Engineers Comments Regarding Surface Water Drainage

Application Reference:	AL/13/25/DOC	Reviewer Reference:	ADC/EXT2/D2134/70
Planning Officer:	Hannah Kersley	Date of Review:	29.04.2025
Site Name:	Karenza Hook Lane Aldingbourne PO20 3TB		
Application Description:	Approval of details reserved by condition imposed under reference AL/154/23/PL (APP/C3810/W/23/3335883) relating to condition number 3 - Construction Management Plan, condition number 5 - surface water drainage scheme, condition number 8 - external materials and finishes and condition number 9 - energy.		
Assessment Number:	1 of 2

Application Reference: AL/13/25/DOC Site Name: Karenza Hook Lane Aldingbourne PO20 3TB	Initial Issue Date: 29.04.2025 Issue Date: 29.04.2025 Reviewer Reference: ADC/EXT2/D2134/70
---	---

Date	Feb 2023	Issue	AS SHOWN	By	Dr. No.
Drawn	TB	Chk'd	EQ	QA'd	435050-221P

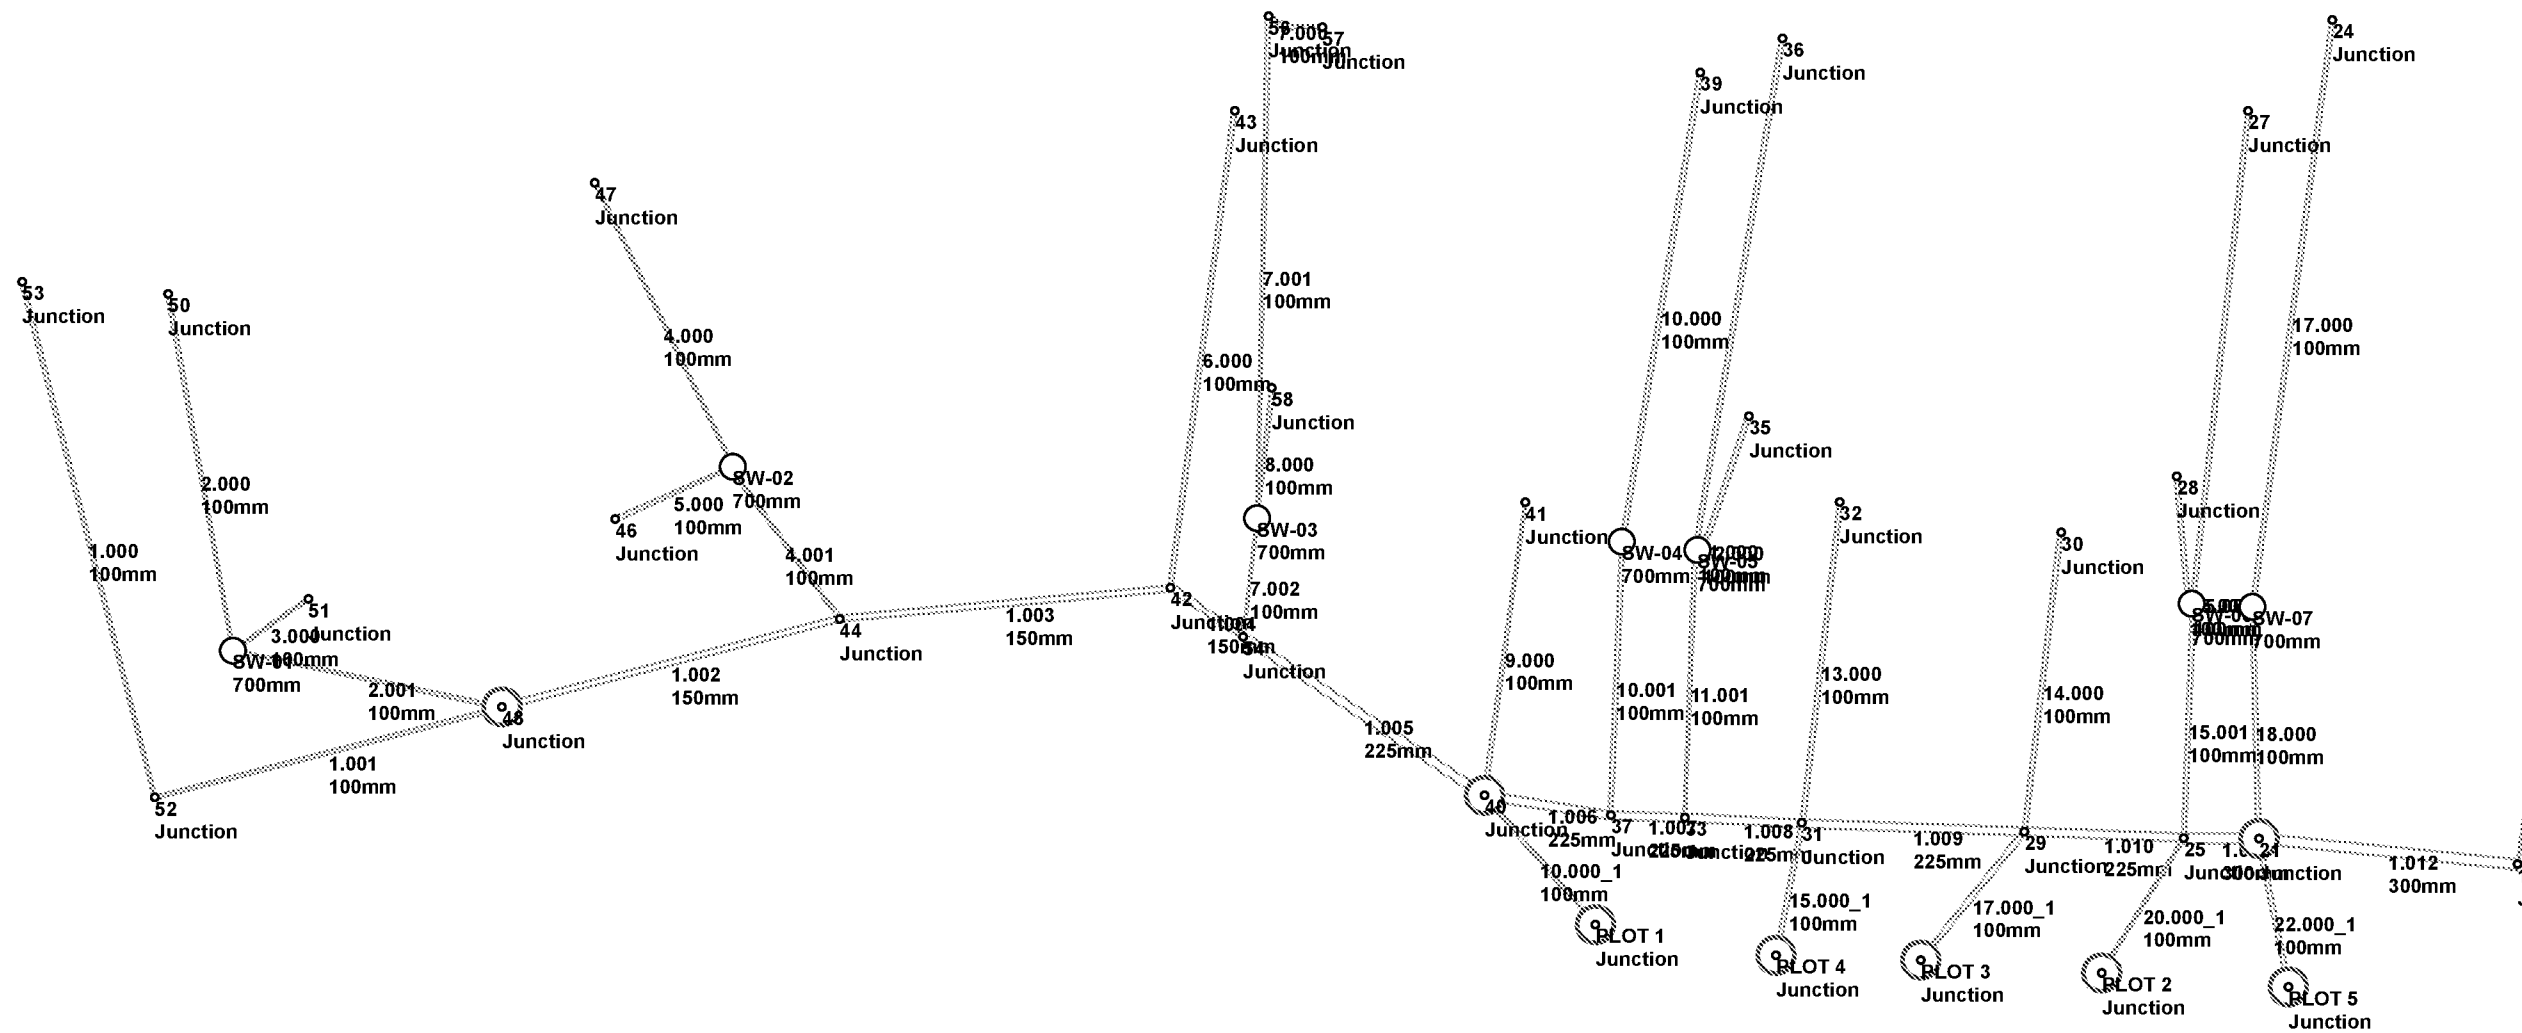
9.	The drainage strategy report, 4.16 makes reference to urban creep of 10% being included, however this calculation is not demonstrated clearly on drawing 435050-221P2.

14.	The hydraulic calculations specify node SW-13 as a vortex flow control with an invert of 9.49m, however drawing 435050-221P2 shows this to be higher @ 9.494m. As cited above, for certainty the as-built levels must be used as they may not correlate with the phase 1 design.

18.	The cover level and invert levels for numerous nodes do not appear to correlate wholly with drawing 435050-221P2.				
19.	Please explain wat is the relevance of a 1:500 return period has been demonstrated, also with CC.

20.	Drawing 435050-221P2 is very difficult to review where phase 1 is greyed out and the key does not clarify all items i.e. its is assumed the pink text represents the phase 1 formation levels?

21.	Drawing 435050-221P2 requires formation levels at all corners and at outlets/inlets of all permeable pavements.				
22.	Rainwater pipes run through silt traps (catchpits) and into the permavoid. Please provide a construction detail of how this is interfaced.

23.	Please provide construction details for all features identified on drawing 435050-221P2.				
24.	Measures to protect the permeable pavement (asphalt construction) during the construction period must be annotated on the drawings to ensure that it does not become silt up prior to completion of the project.

29.	Please demonstrate how the Permavoid blocks will be installed to formed the curved edges of the drives.				
30.	Drawing 435050-221P2 is very light on spot levels, no contours it is not possible to deduce where exceedance run-off will travel.
